Please add to application

Good morning Anita,

No problem – I've attached a quick drawing showing the comparison between the building footprints and massing in regards to the northern elevation – hope this helps to clarify the changes to the scheme.

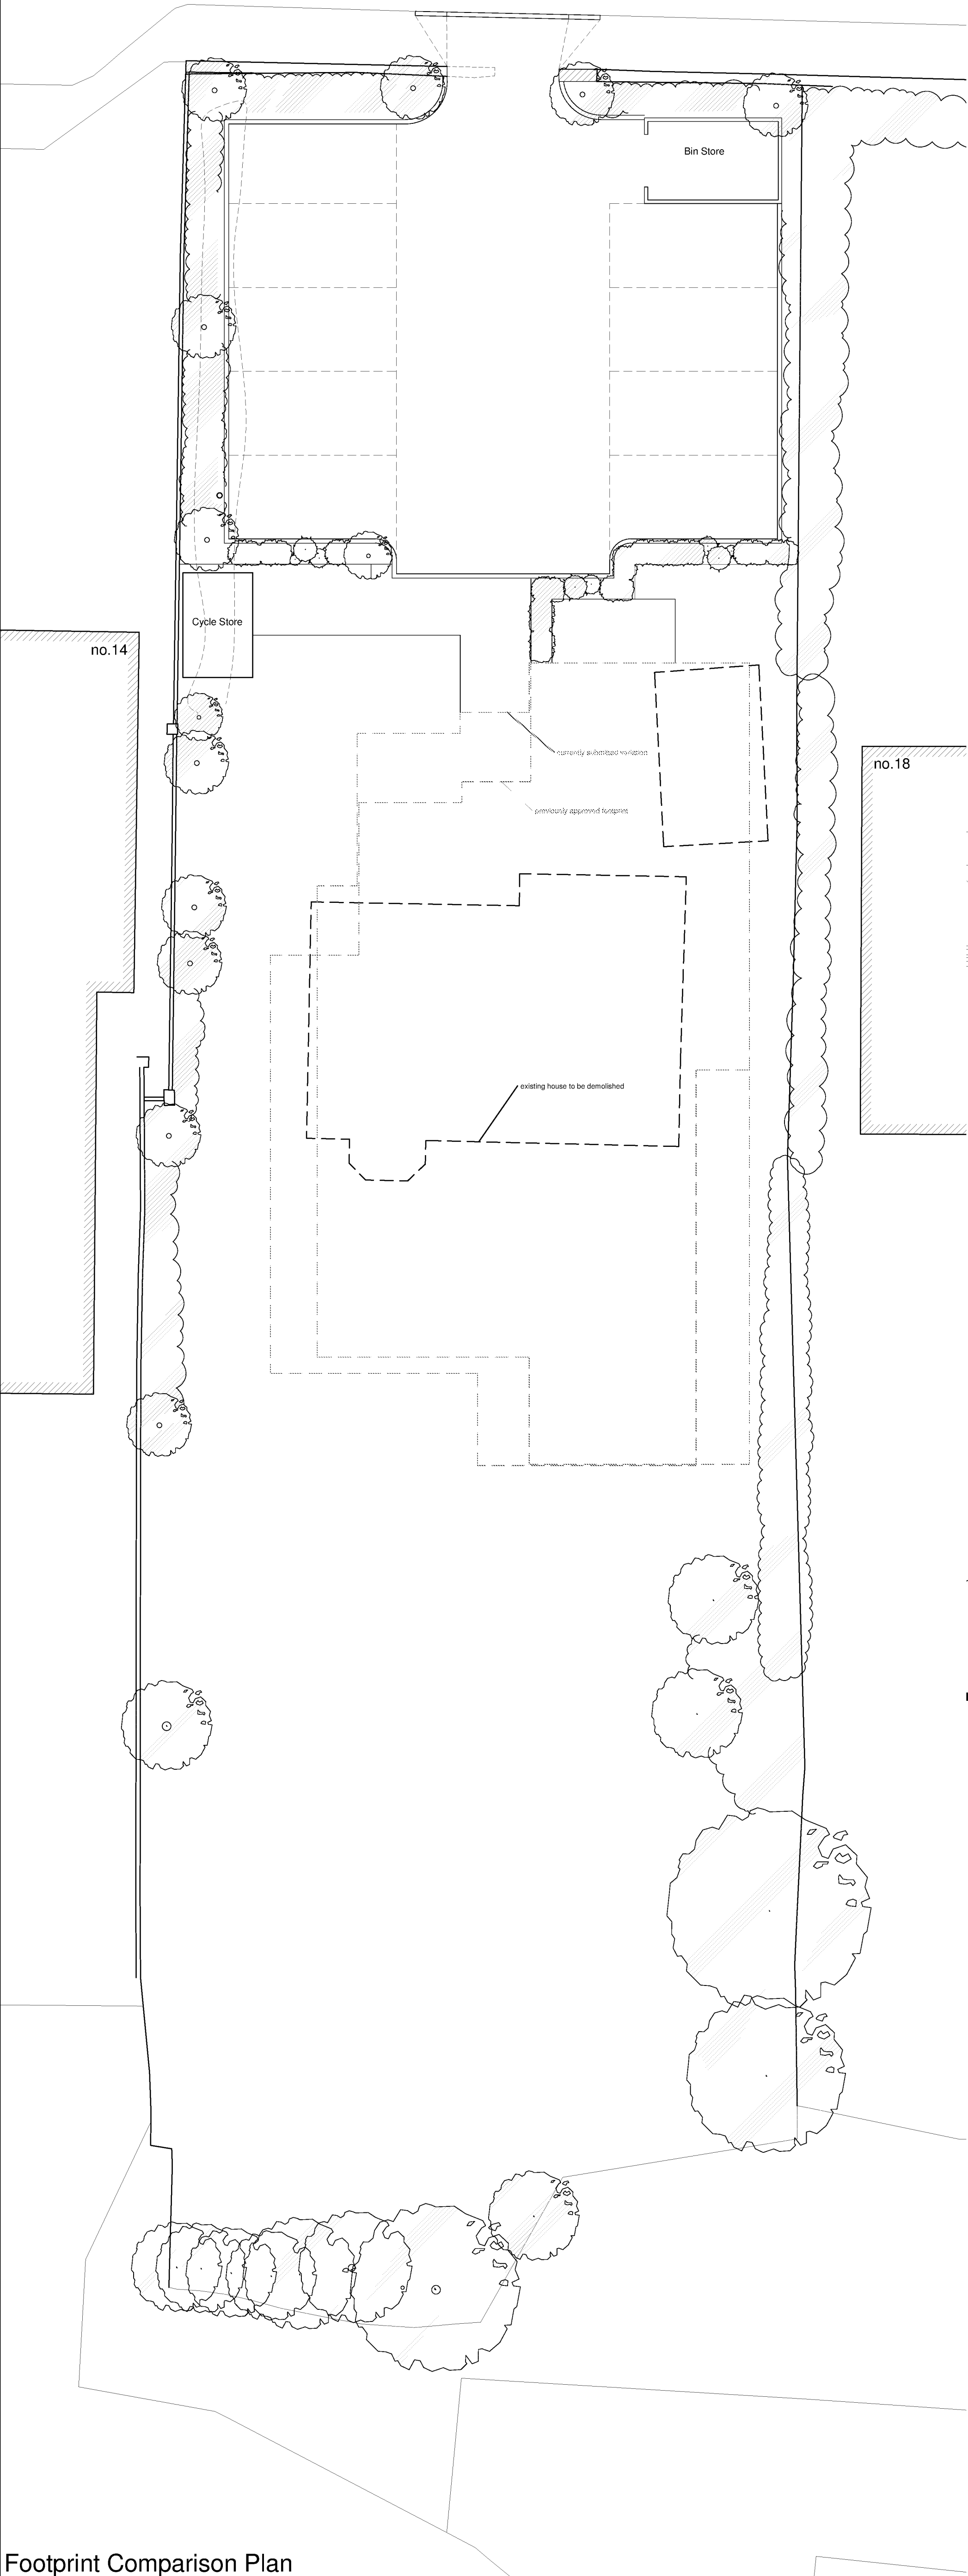
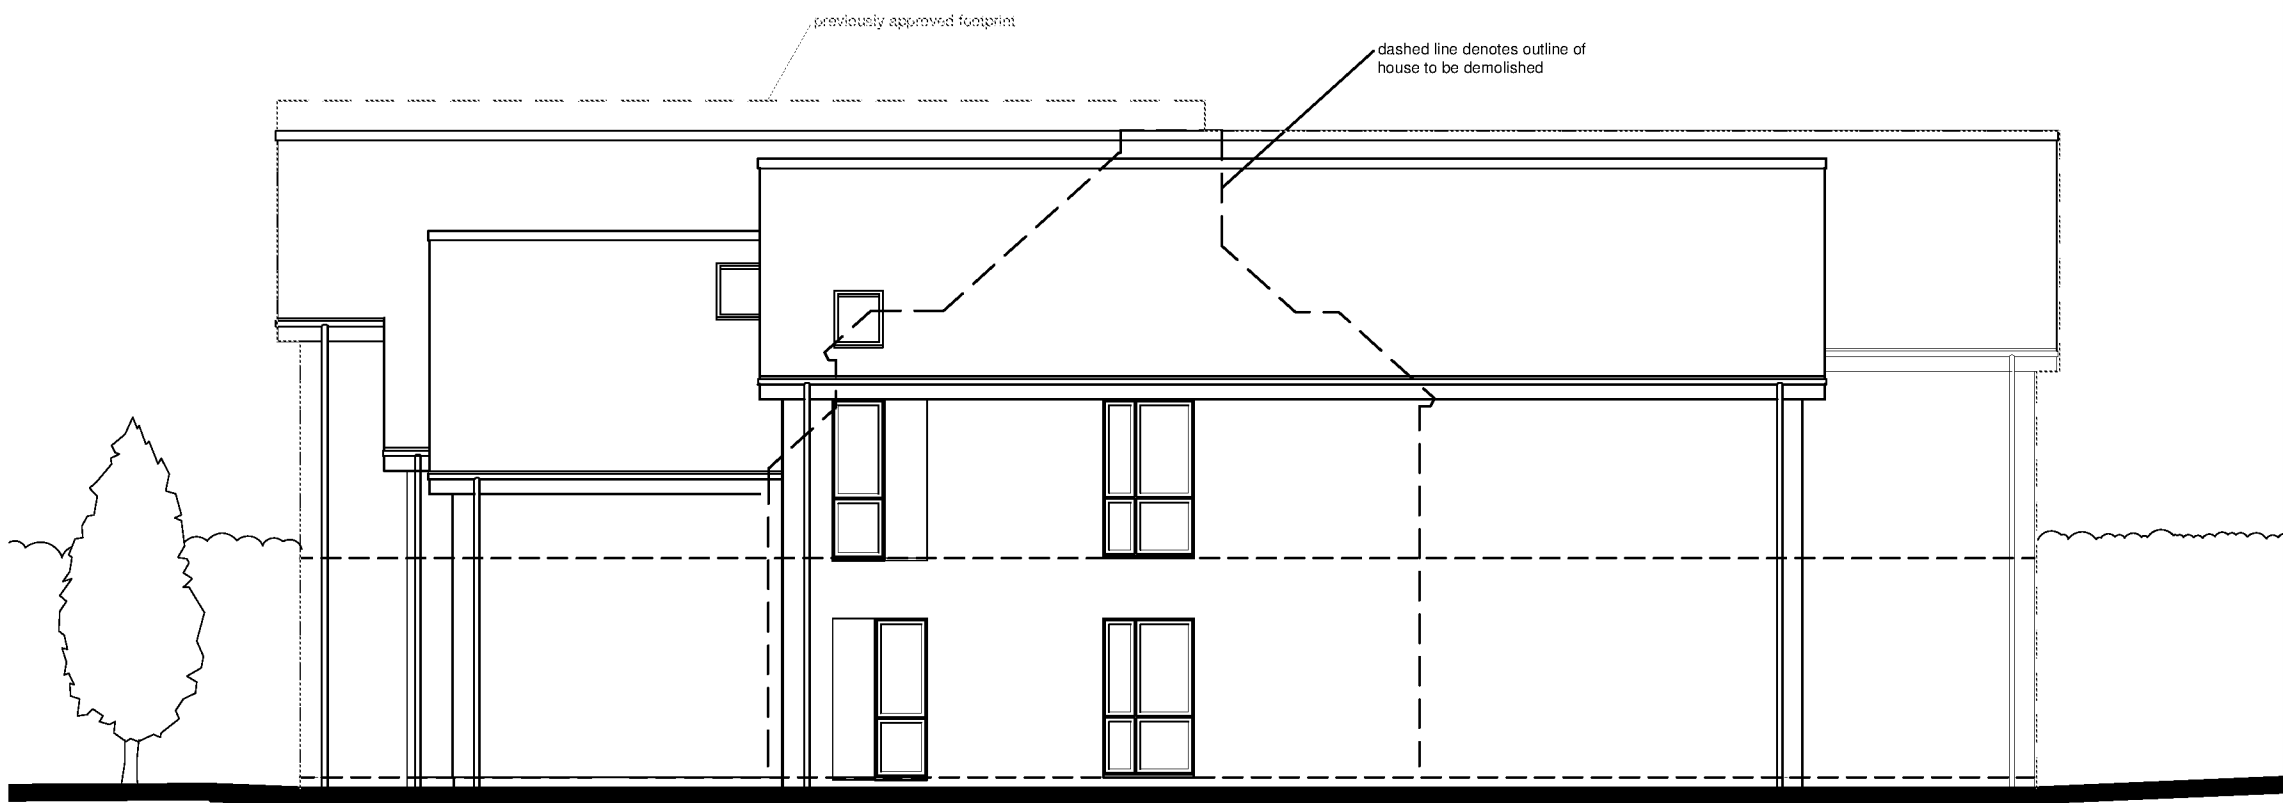
In order to clarify the changes please can you provide comparative elevations and block plan to illustrate the differences between the approved plans EP/121/17/PL and the above application. I appreciate that this may take a week to provide and that the plans will then need to be processed so I would appreciate your agreement to an extension of time on the application until 22-11-2019 to cover this period.
